Our Ref: LU/246/19/NMA
Your Ref:

Application for A Non-material Amendment Following a Grant of Planning Permission

Development Non-material amendment following the grant of reference LU/59/19/PL for installation of an ATS cart canopy, re-provision of the existing cycle shelter and re-provision & relocation of the existing smoking shelter from north-east corner of Building 5 to south-east corner of Building 5.

Location Land at Watersmead Business Park Worthing Road Littlehampton

PROPOSED NON MATERIAL AMENDMENT SITE PLAN

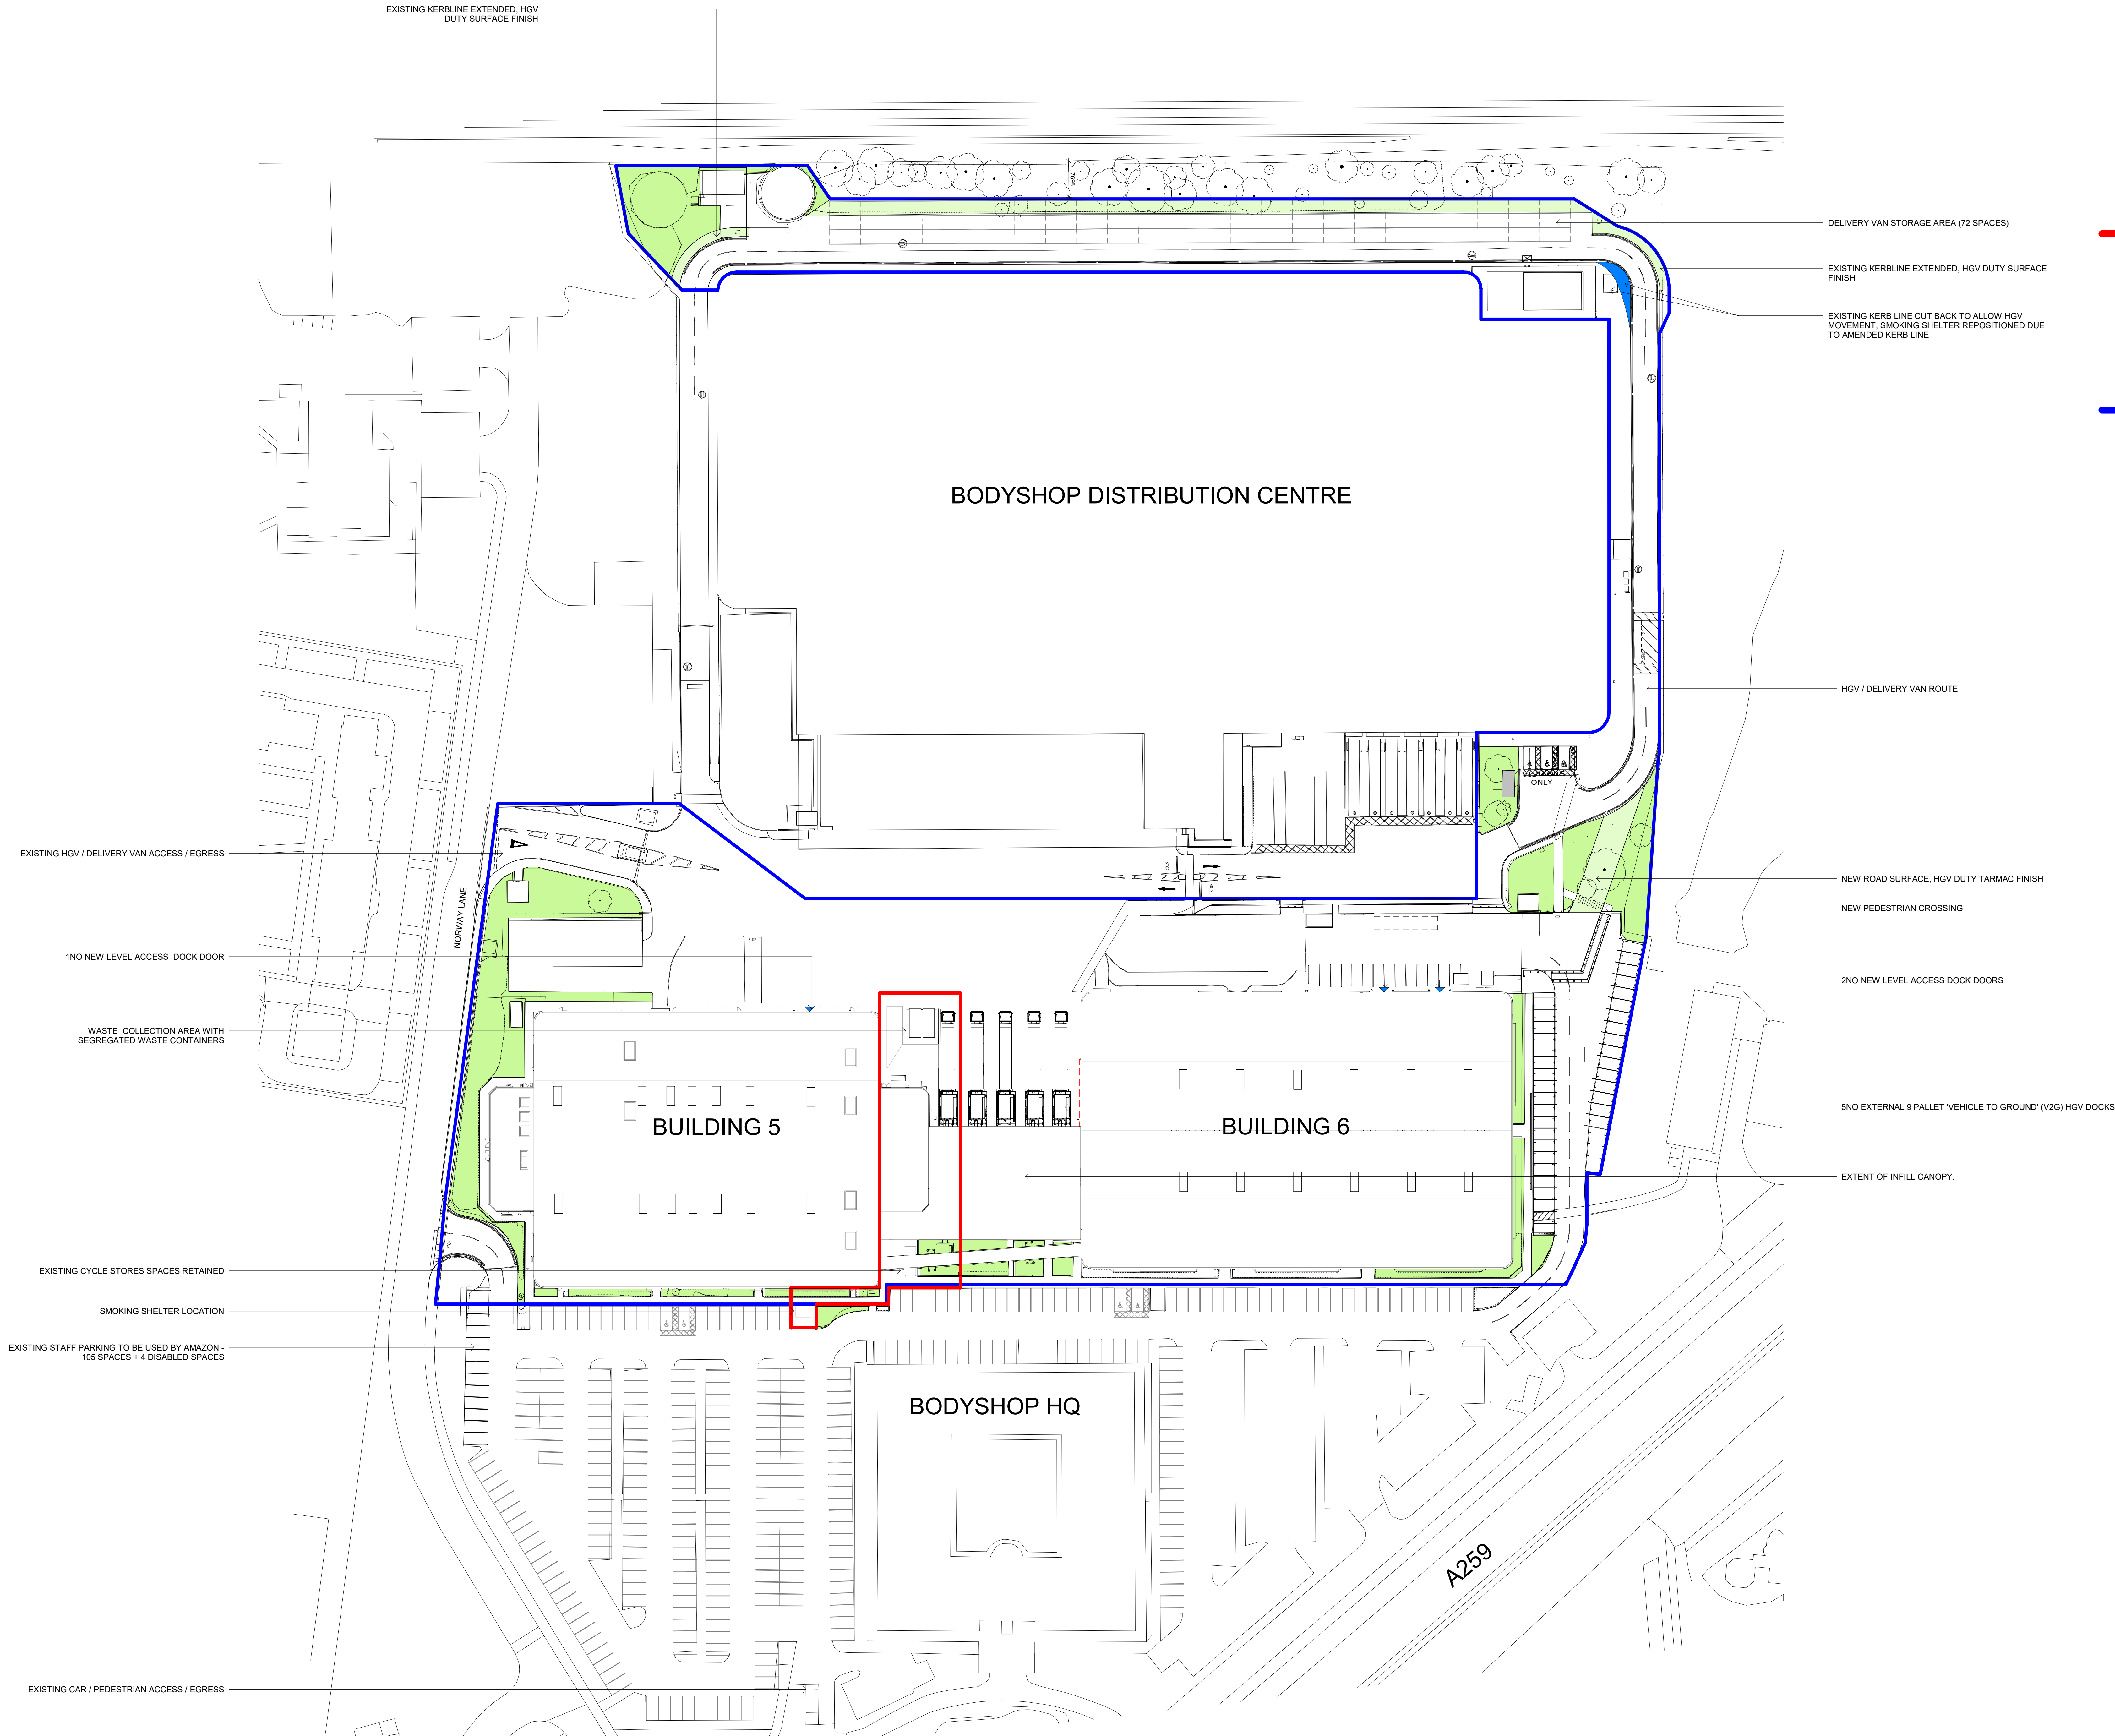
The re-provision and relocation of the smoking shelter is unacceptable as a Non-Material amendment as it is not within the approved red edge, therefore a new planning application will be required.
